**WEST SUSSEX COUNTY COUNCIL
INFRASTRUCTURE CONSULTATION**

SUBJECT: BE/93/09/- Drop kerb and vehicle crossover.

204, Chichester Road, Bognor Regis, West Sussex

BLOCK PLAN scale 1:500

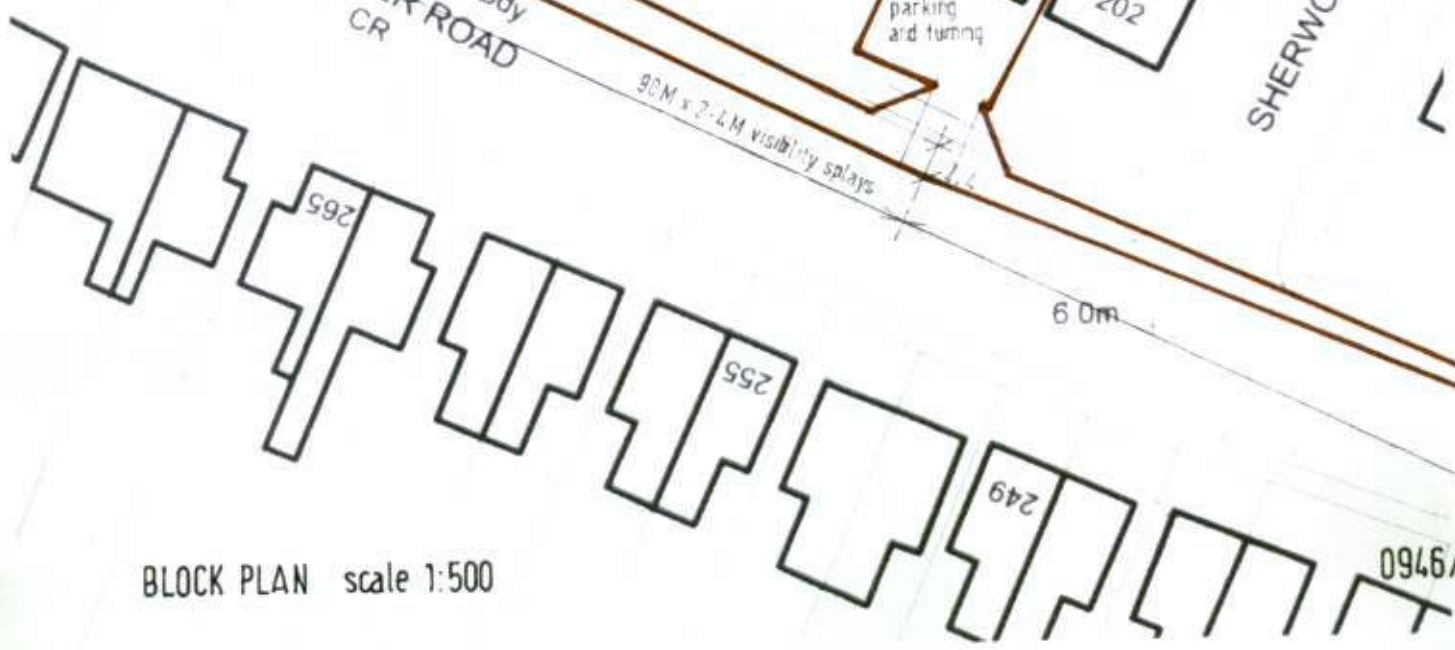
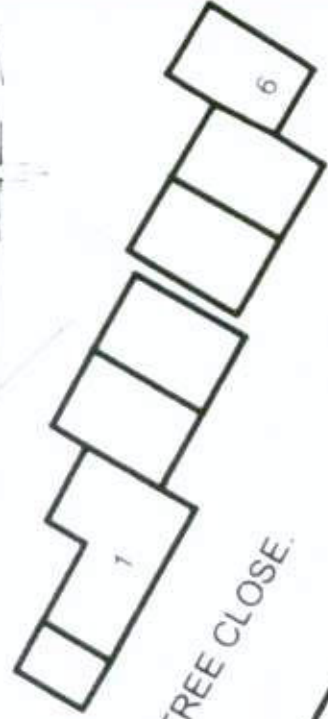
Based on the submitted information and available WSCC map information I would not foresee any significant issues with the formation of an access in the location shown. Based on the speed limit of the road and the guidance issued within Manual For Streets, visibility splays of 2.4 by 43metres would be required. To the west and the east 43 metres it would appear this distance can be achieved. Other properties along this part of Chichester Road have similar arrangements without apparent omission and given the presumed low number of daily vehicular movements, it is not anticipated this proposal would adversely affect highway safety.

As the new access is only serving the one dwelling a 3 metre wide access would be sufficient for these uses. Any works on the highway must be agreed with the WSCC Local Engineer and carried out under licence. I would also require the driveway area and car parking spaces to be constructed in a bound material and that suitable drainage methods are installed to prevent private surface running onto the public highway.

If the LPA are minded to approve this application, a condition securing the new access and vehicular visibility splays should be included.
